PLANNING CONSULTATION RESPONSE

Application No	2026/0306
Proposal	Variation of condition 2 to application 2025/0459 (Garage extension and boundary wall alterations) to allow for alterations to boundary wall design
Address	1 Poplar House Farm Close, Cudworth, Barnsley, S72 8FP
Date of Consultation Reply	21/05/26
Consultee	Highways DC

Proposed Front Elevation

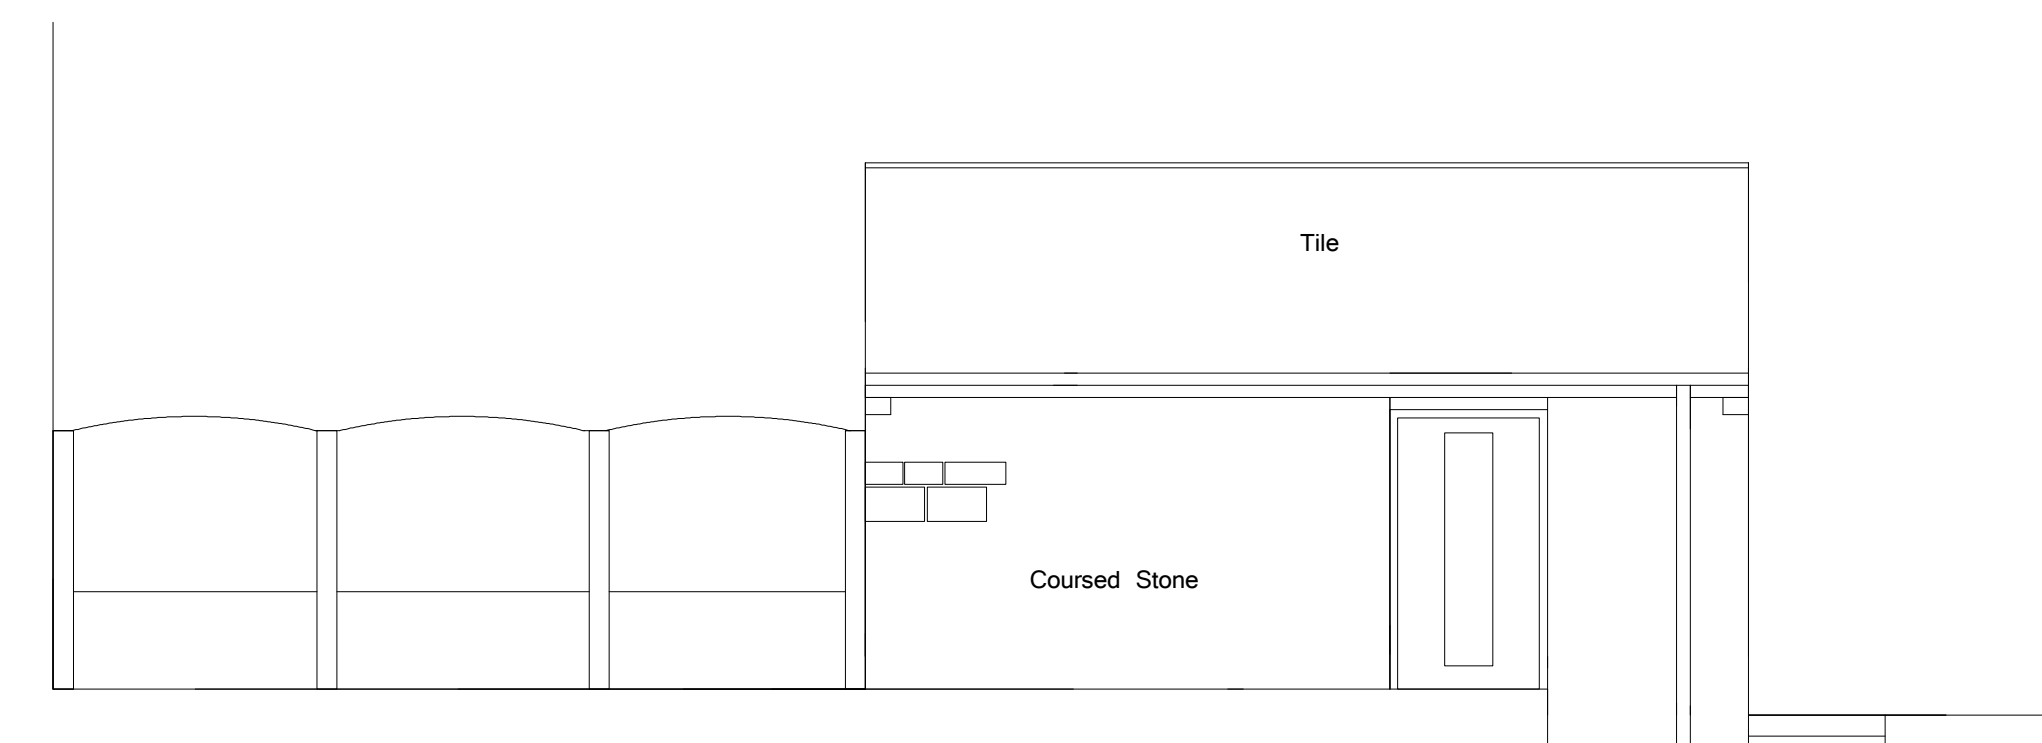
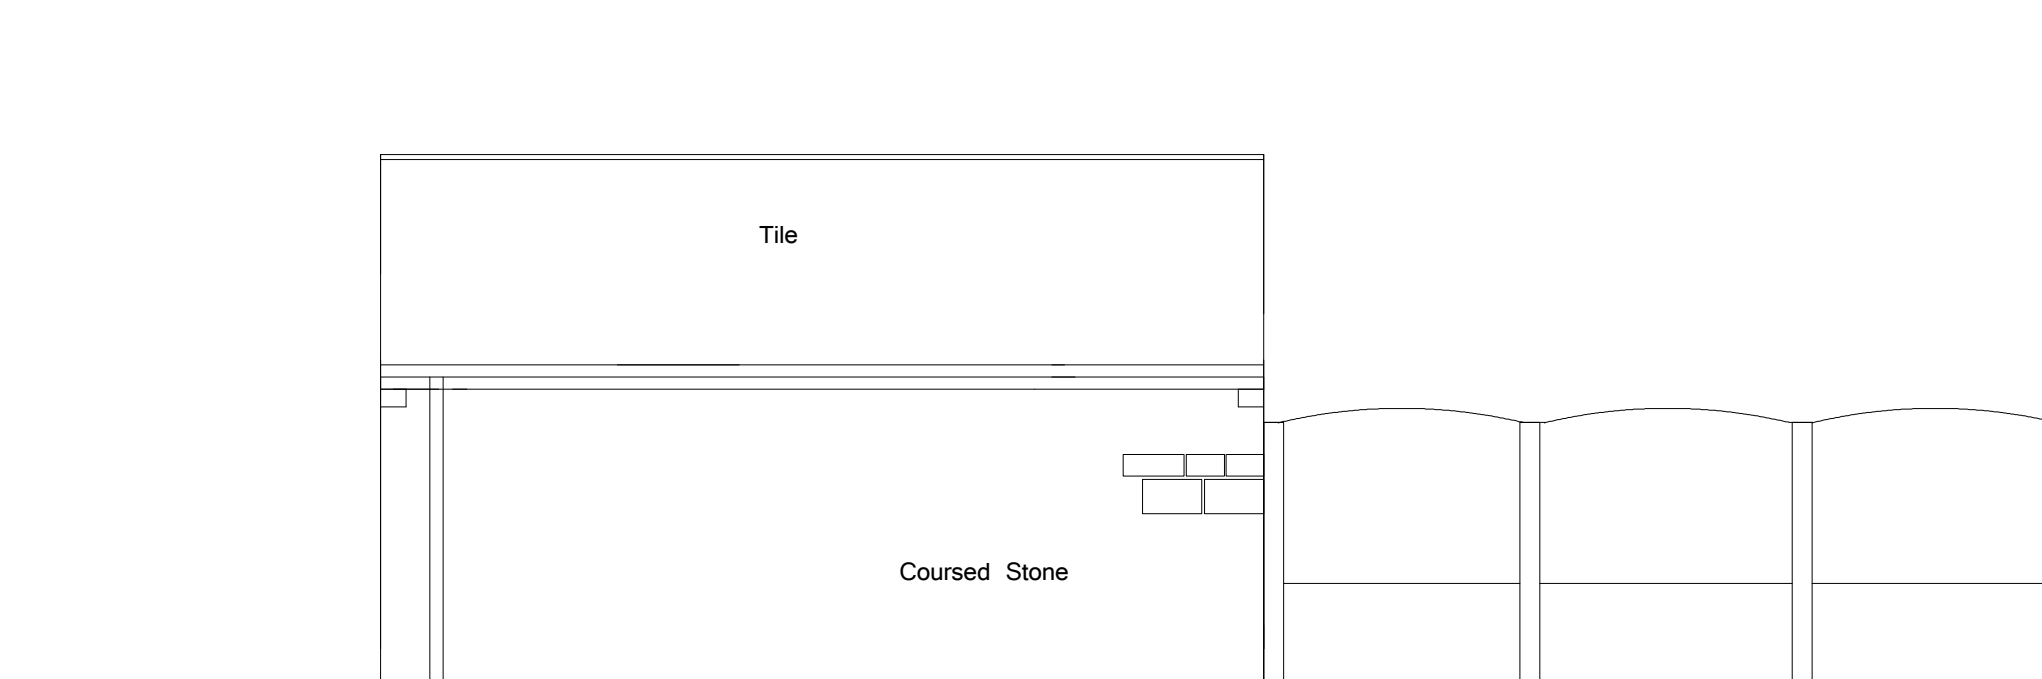
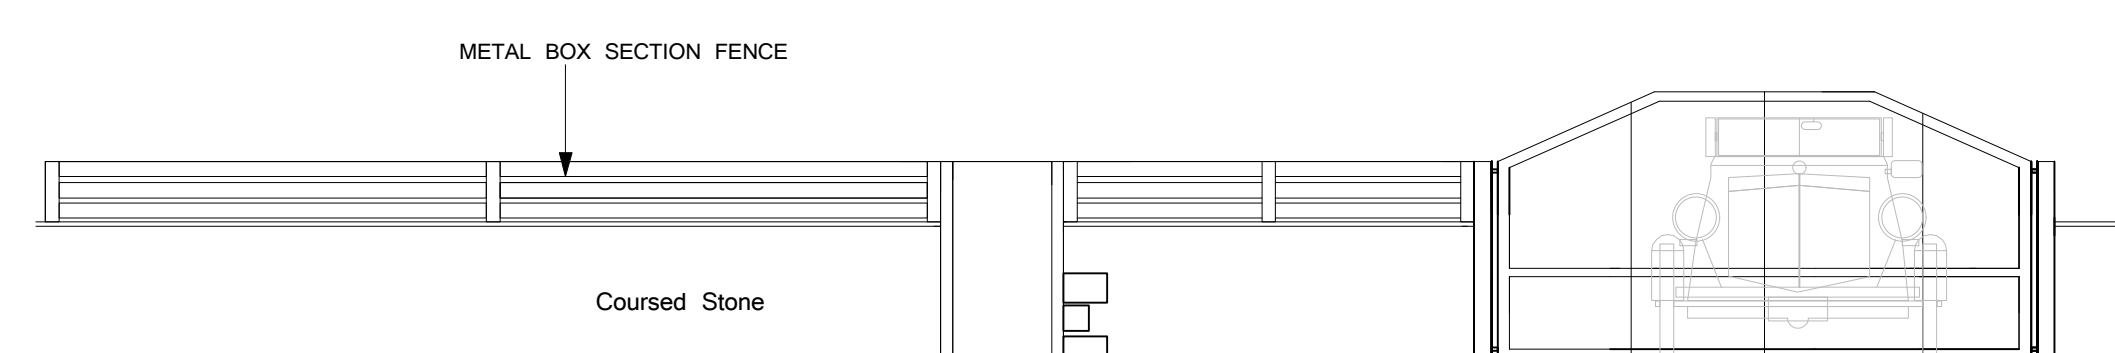
The proposed amendment would see the construction of a boundary wall raising 0.9m in height above the hard margin highway edge. As such, the wall will be less than 1.0m above the carriageway and will not impinge on the intervisibility between drivers and pedestrians.

The variation will therefore not impact on highway safety and HDC officers have no wish to raise objection to the application.
